**MONUMENT FIRE DISTRICT**

To: Development Review, El Paso County  
From: Jamey Bumgarner, Fire Marshal  
Subject: Monument Glamping II, AL Special Use  
Date: August 23, 2023

The Monument Fire District has reviewed the plan for Monument Glamping II. Based on our initial review of site access, water supply, and fire mitigation, we have the following comments.

SITE PLAN

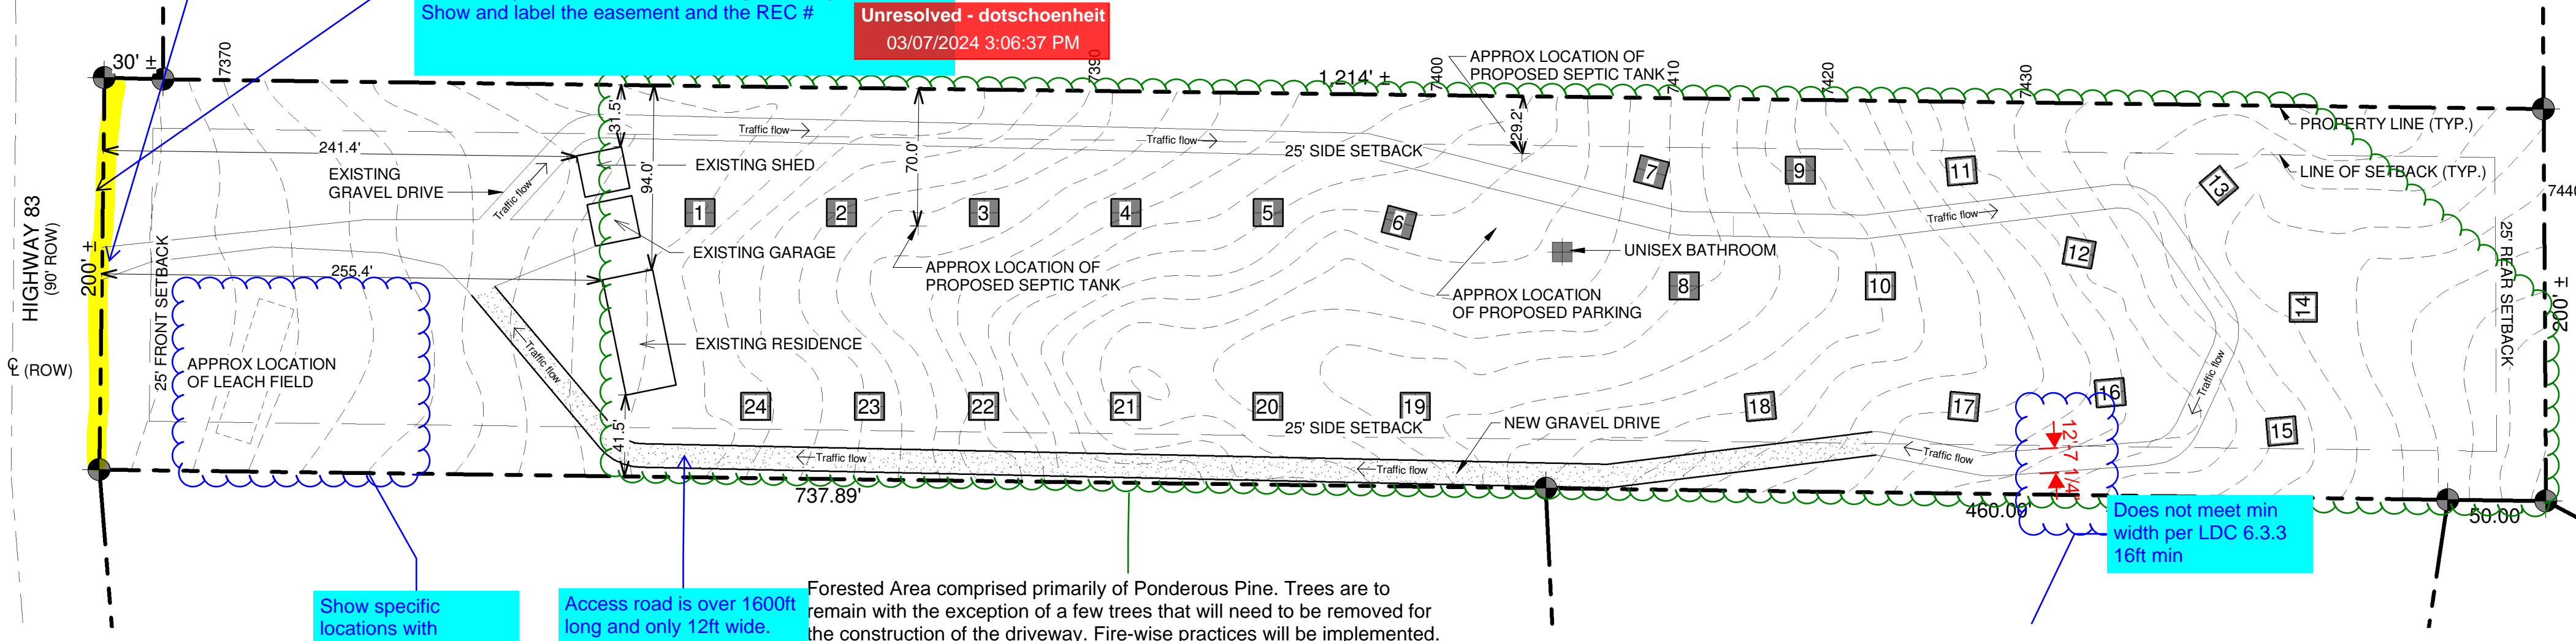
- The access driveway or easement to the sites is over 1425 feet long and only 12 feet wide. We will need at least one of the conditions for a turnout or turnaround met as outlined within the adopted 2015 Fire Code for FD access as listed in Appendix D.
- There are no mentions of water supply for firefighting efforts. We want to acknowledge that the water supply will require water tenders to shuttle water in the event of a fire; therefore, the roadways must conform to the adopted fire codes (2015 IFC) for FD access.
- Fire mitigation is not mentioned; this project will bring fire within the forest. We recommend that the Colorado State Forest Service be engaged and all sites be mitigated to their recommendations.
